Rezoning Petition Review

Rezoning Petition #: 20-137

Location of Property: Approximately 28.8 acres located along the north and south side of Rocky River Rd, east of Rockland Dr and west of Old Concord Rd.

DATE: 08/11/20	MPIC: WILL
DRAWN BY: DSB	CHECKED BY: WILL
PROJECT NUMBER: 00777.00	
SCALE: 1" = 60'	
TITLE: CONCEPTUAL SITE PLAN

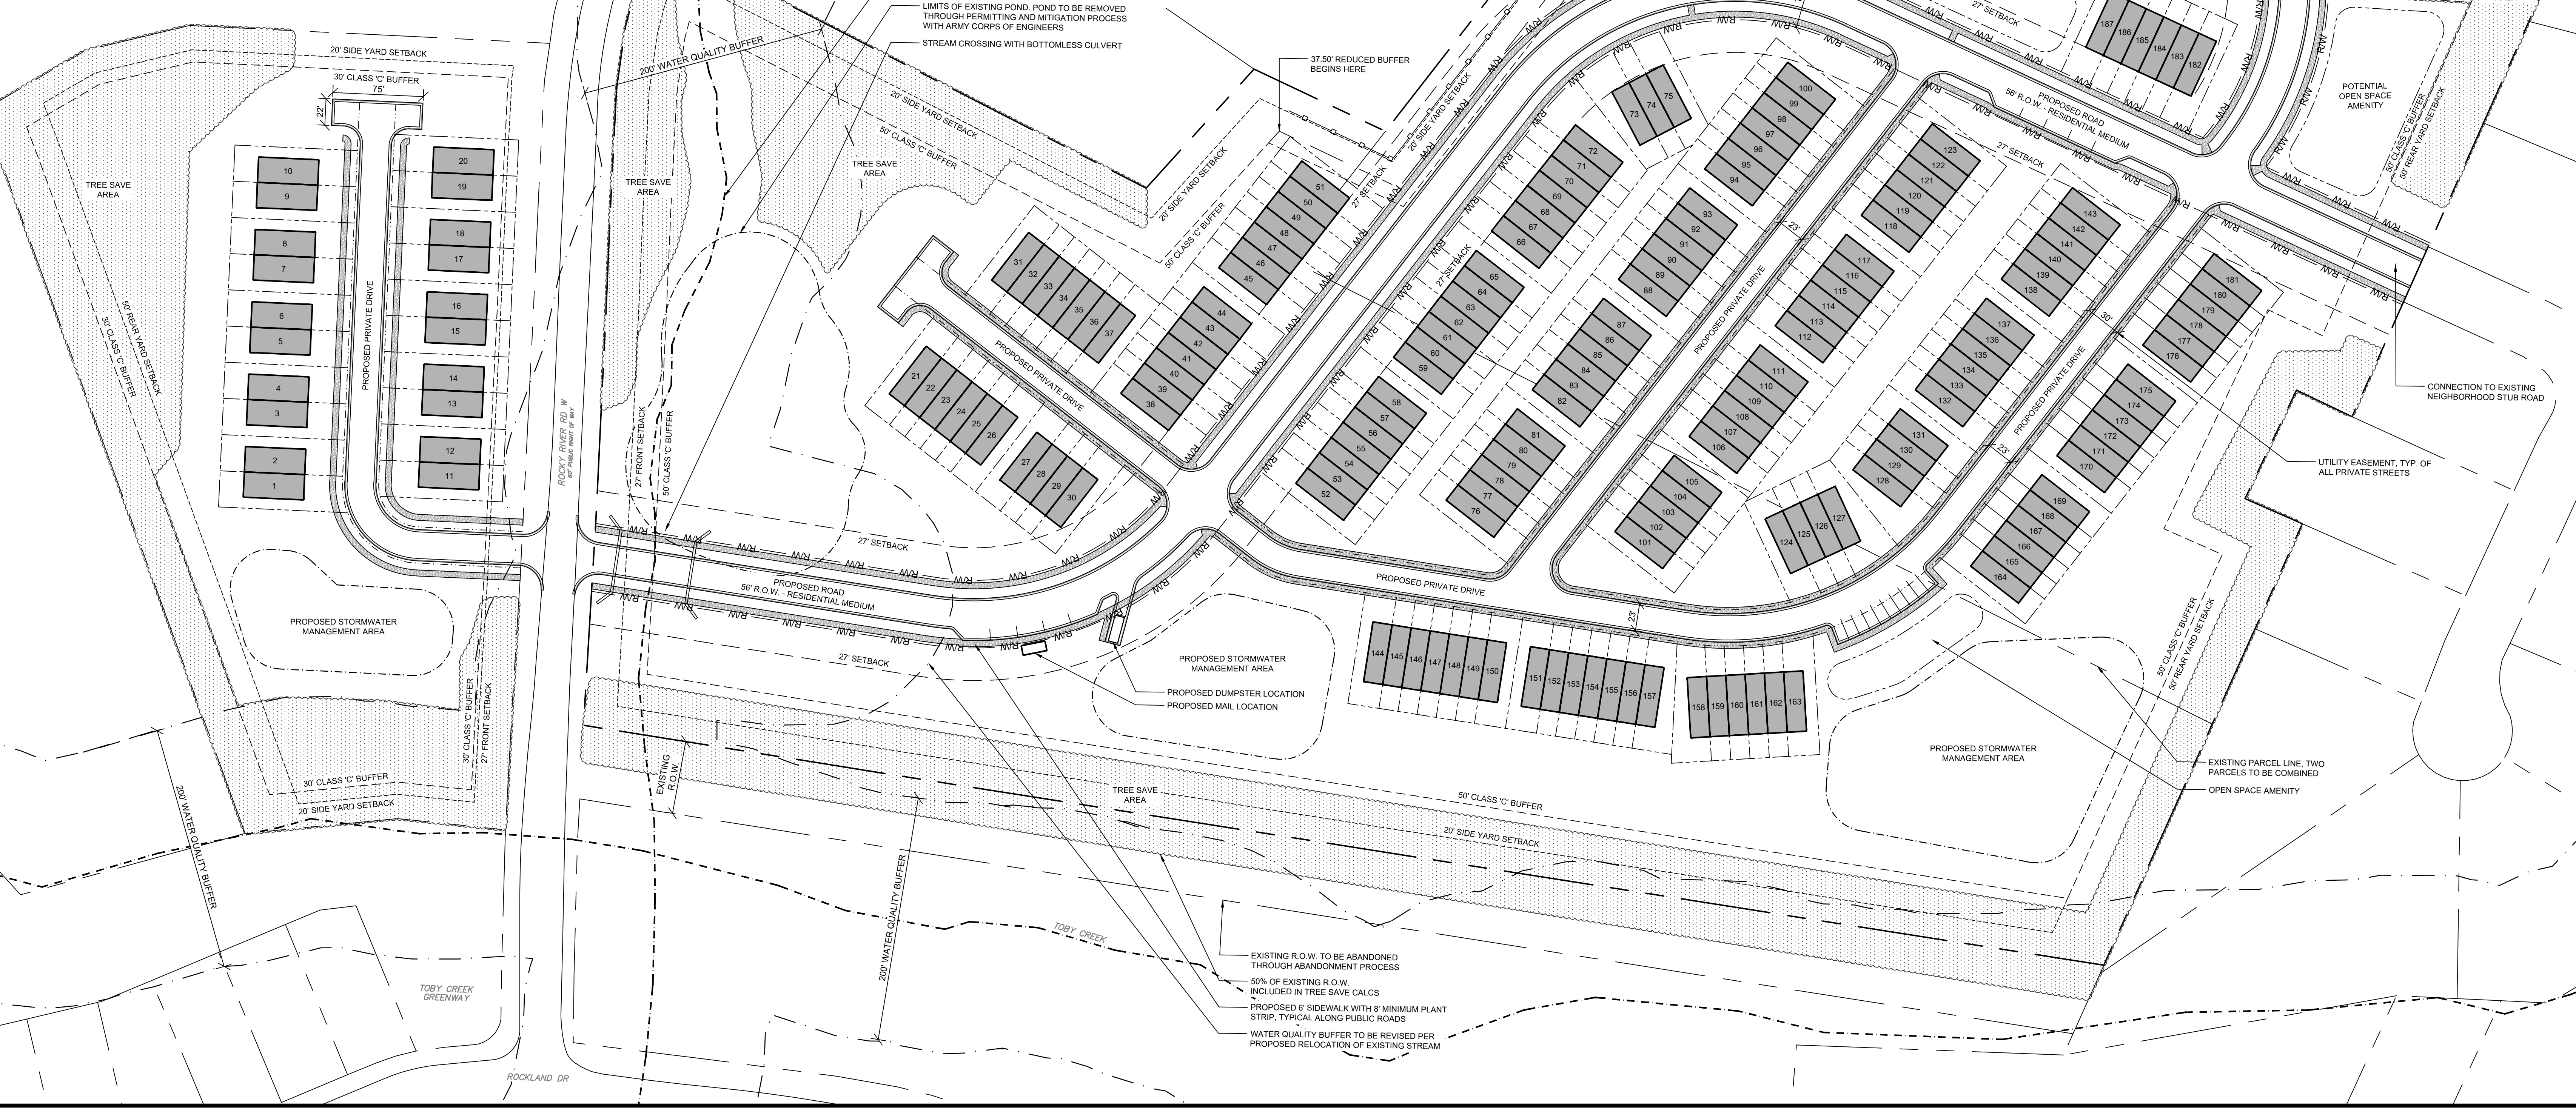
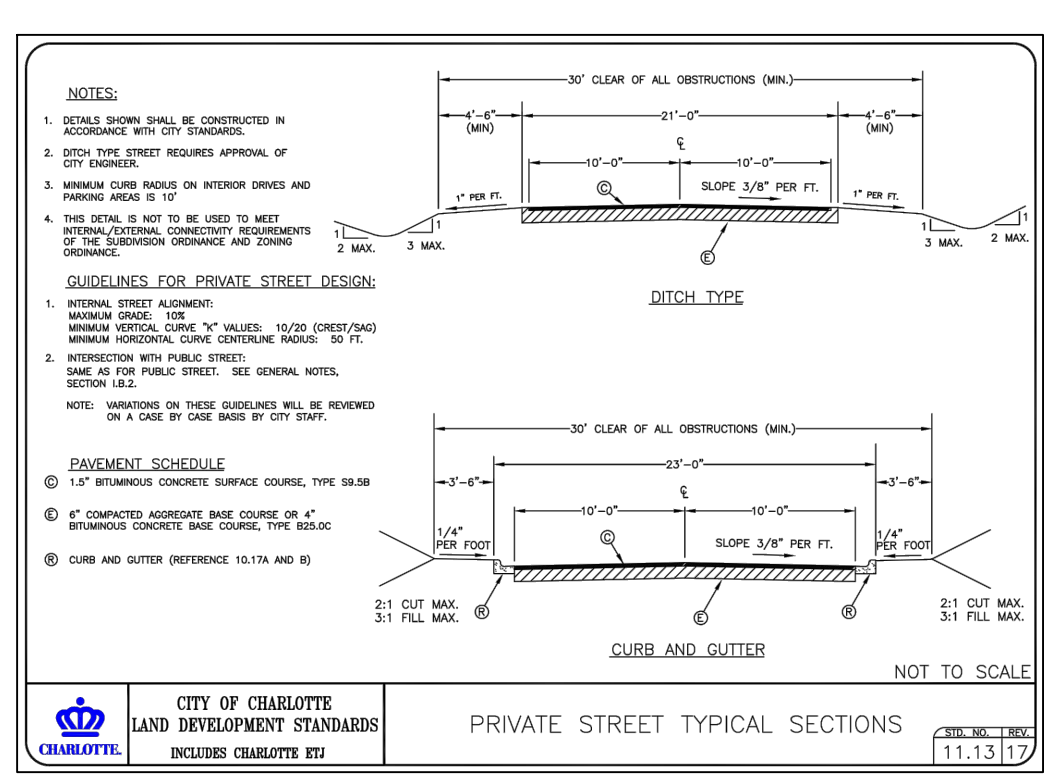
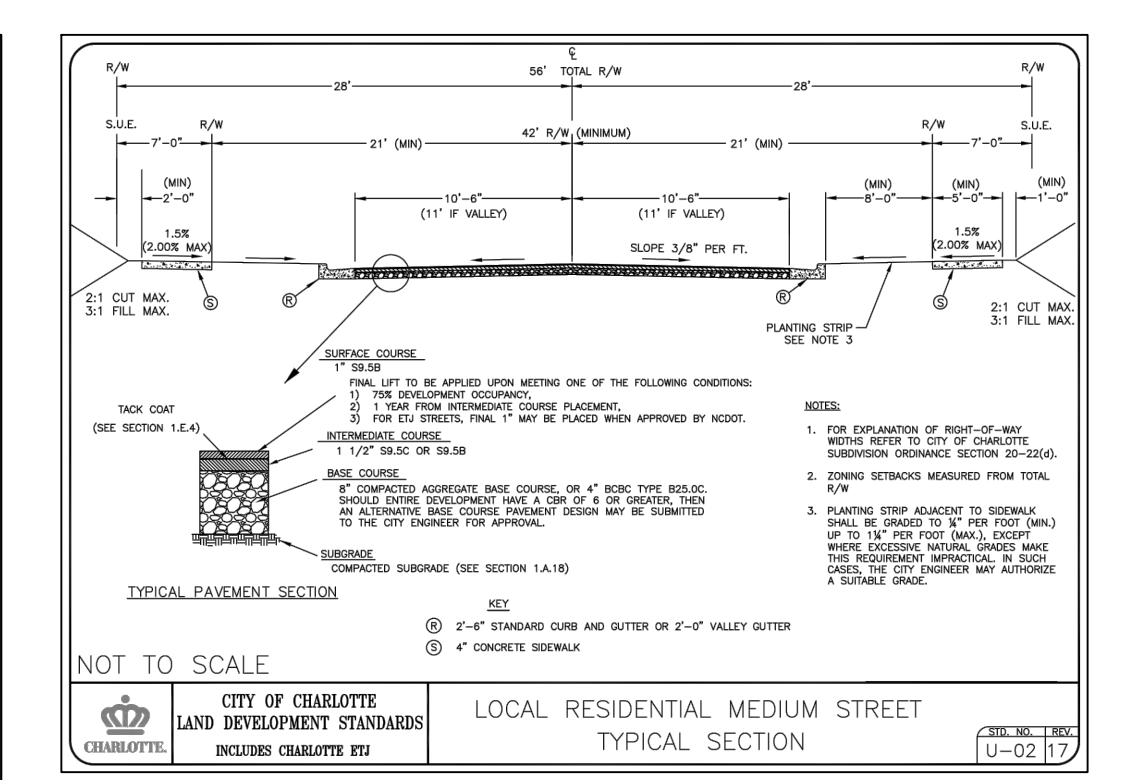
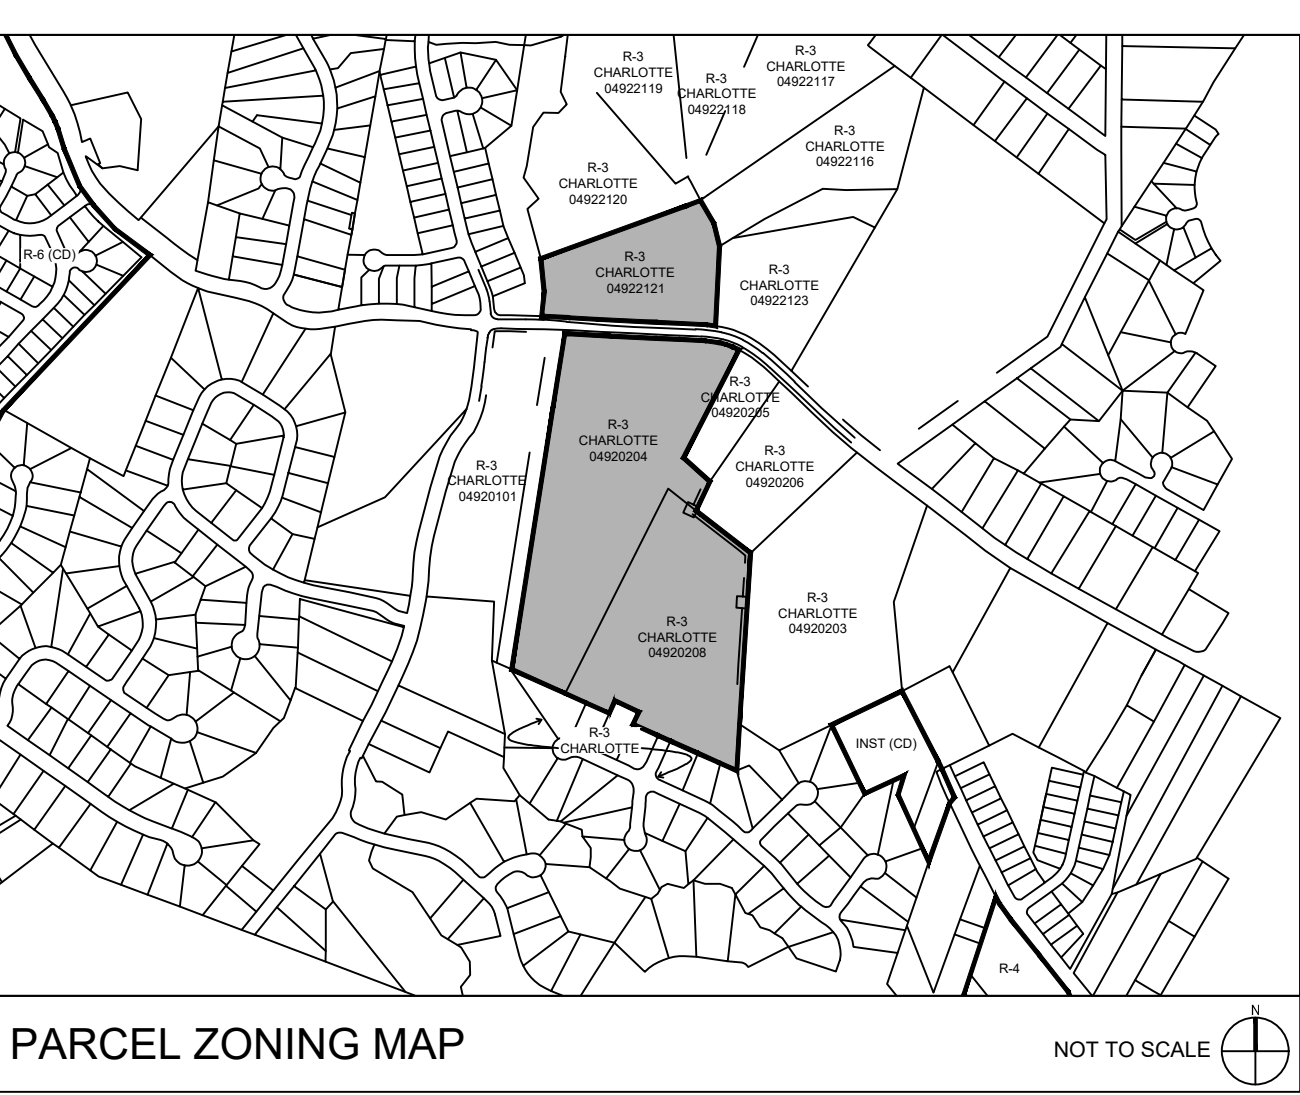
Please revise the "200' Water Quality Buffer" to read "100-ft Undisturbed PCSO/SWIM Buffer". Please note these 100-ft buffers are measured from the stream top of bank and outwards for each side of the stream.

City of Charlotte GIS indicates a FEMA Floodplain on portions of the property. Please show and label. Petitioner is advised the 100' SWIM/PCSO Stream Buffers on the site may require the inclusion of 50% of the flood fringe area as additional stream buffer. Delineation of the additional stream buffer area may be deferred to the permitting process and is not required to be shown on the rezoning plan.

Please include the following notes on the plan sheet under "Environmental Features":

- *Development within any SWIM/PCSO Buffer, including potential buffers around the existing pond on site, shall be coordinated with and subject to approval by Charlotte-Mecklenburg Storm Water Services and mitigated if required by City ordinance. Petitioner acknowledges intermittent/perennial stream delineation reports are subject to review and approval upon submission of development plans for permitting and are not approved with rezoning decisions.*

Please remove the following notes/callouts on the rezoning plan sheet as they are not approved during the rezoning process and are part of the full development plan submittal process:

- *Existing stream to be mitigated at point of pond and reconnect per recommendation of wetlands consultant*
- *Limits of existing pond. Pond to be removed through permitting and mitigation process with Army Corps of Engineers.*
- *Stream crossing with bottomless culvert*
- *Water quality buffer to be revised per proposed relocation of existing stream*
